WELWYN HATFIELD COUNCIL – DEVELOPMENT CONTROL
DELEGATED REPORT

APPLICATION No:	S6/2007/1519/AD
------------------------	------------------------

Following planning permission earlier this year to change the existing car dealership into a dual franchise for Peugeot and Renault which required some changes to the external layout of parking and access to the current site, along with changes to the external appearance of the existing building and new reconfiguration of internal layout of space(S6/20071143 /AD), this application is to amend the existing signage to incorporate signage for one of the 2 car manufactures that will function from the site. A second separate application has been received for the replacement signage for Renault (S6/2007/1701 /AD).

Scale 1:100
Tolerance +-
Drg No Ren0748 planning
Date 9.10.07
Drawn By AHW
Checked By

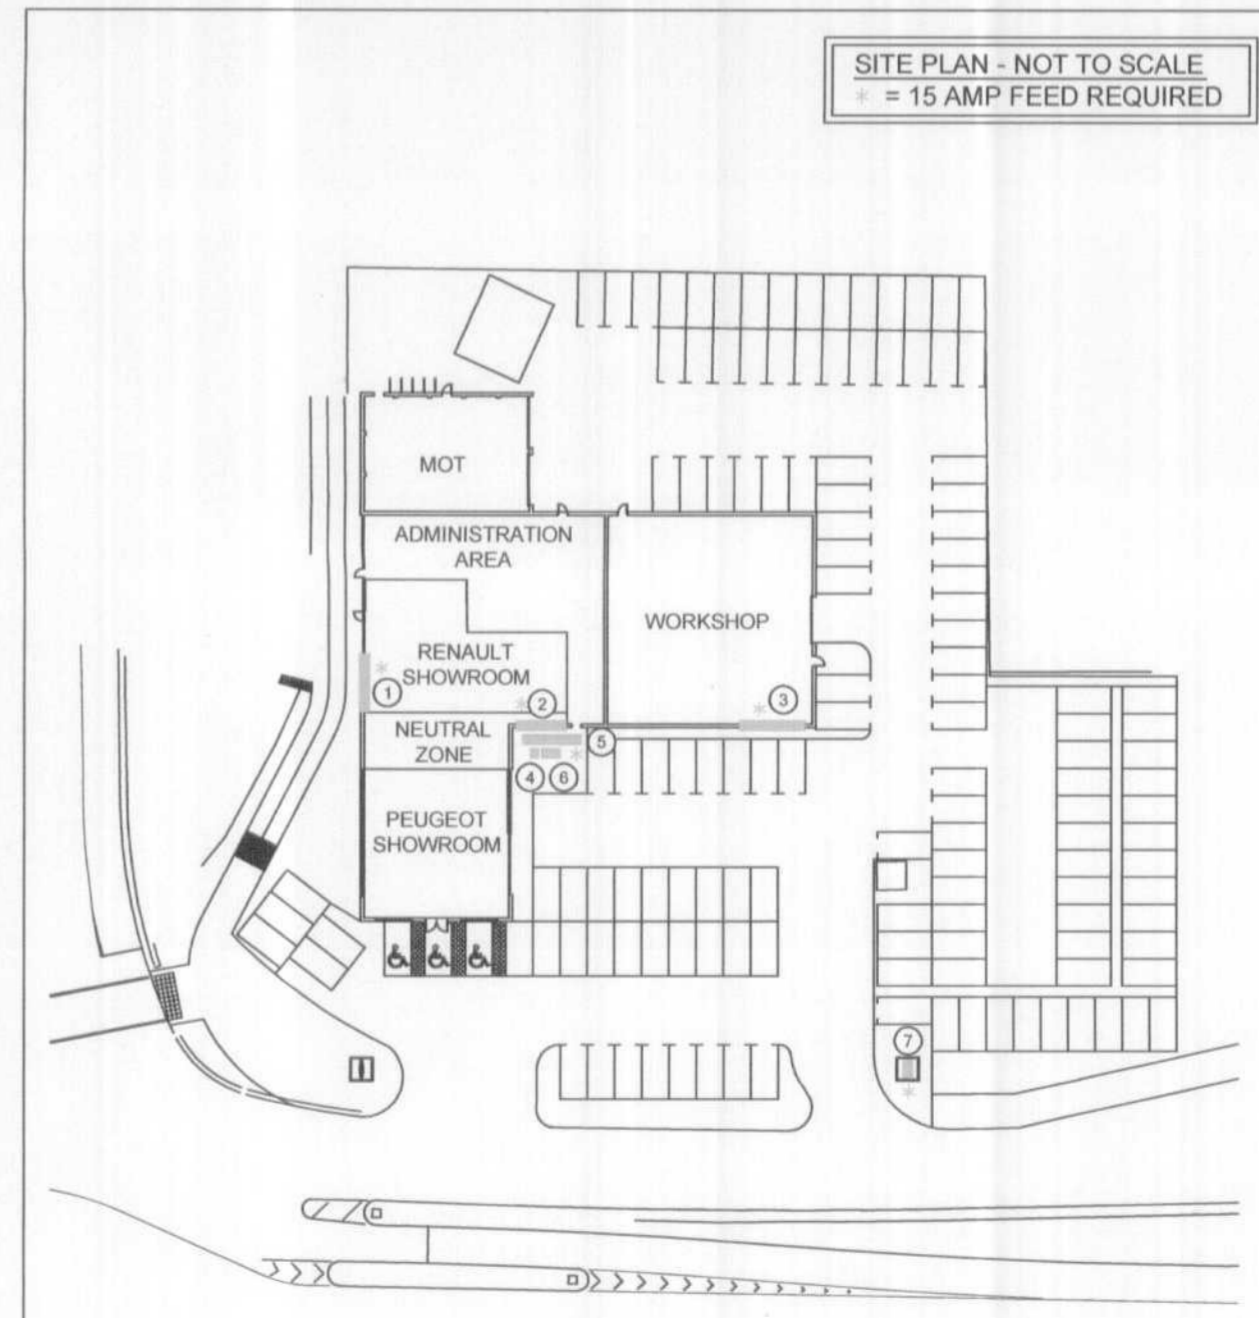
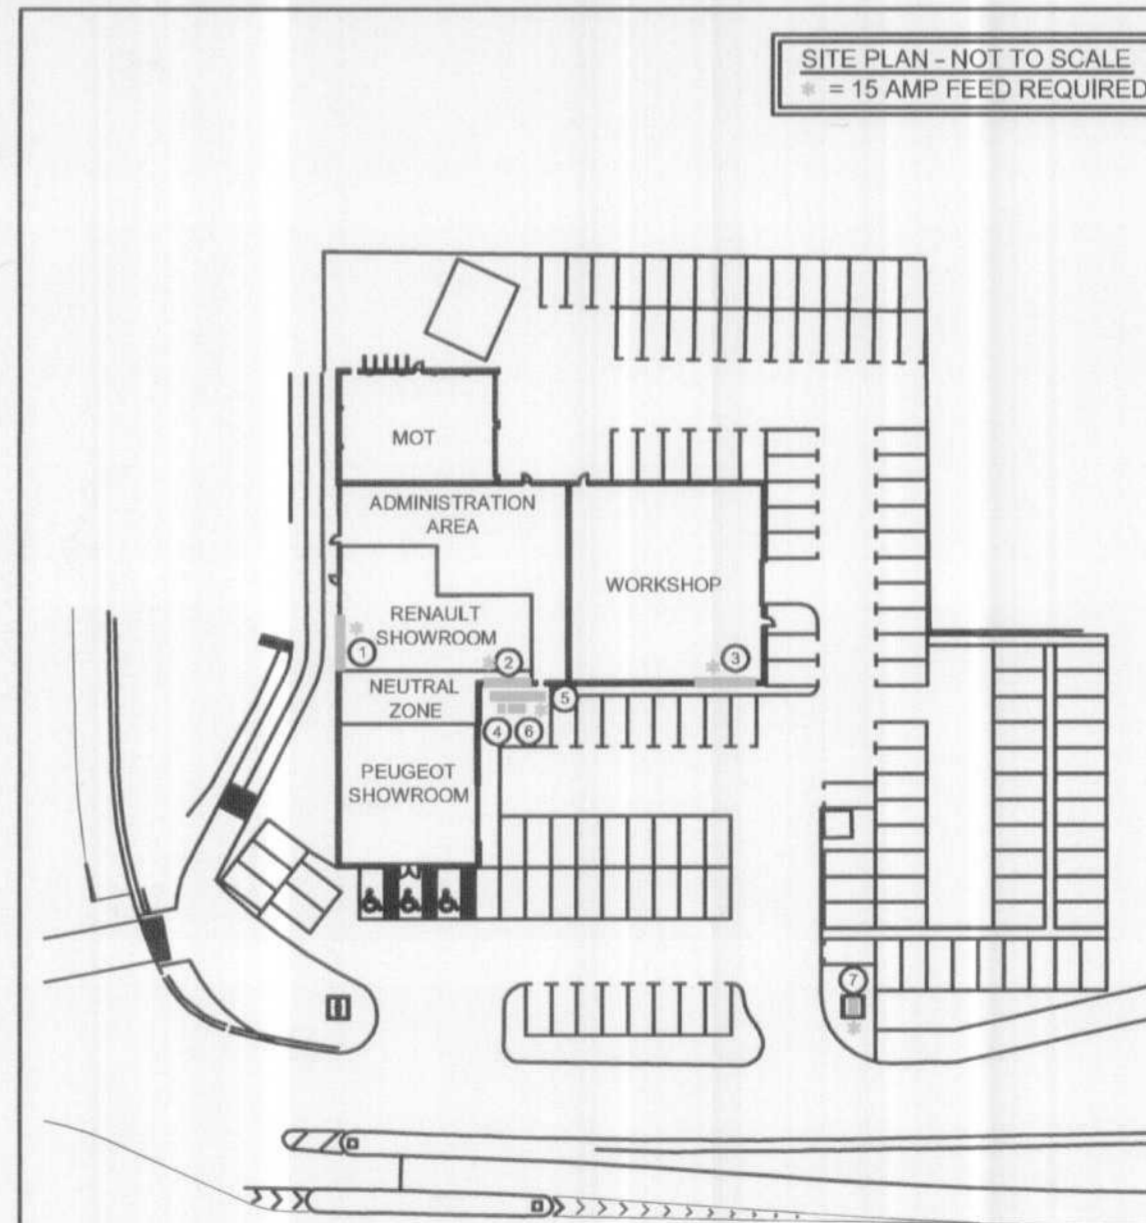
The freestanding sign to the front of the site would be the most prominent one of those proposed, however through negotiation the original one (which was 6.5m high and 1.26m wide) has been reduced to 4.5m in height whilst retaining the same width. This reduction is much more in keeping and scale with the character of the streetscene, and also the white colour to the lower section would look less prominent than maybe other colours. It would also be reasonable to say these 'types' of sign are now a more common feature often found in the forecourt of petrol stations and streetscenes, although, this site is a car dealership.

7. The current existing sign 'Peugeot' granted by application S6/1995/100/AD on 20/03/95 (pole sign) is to be removed prior to the erection of the sign No.7 (shown on approved drawing Ren0748planning Rev A) hereby granted.
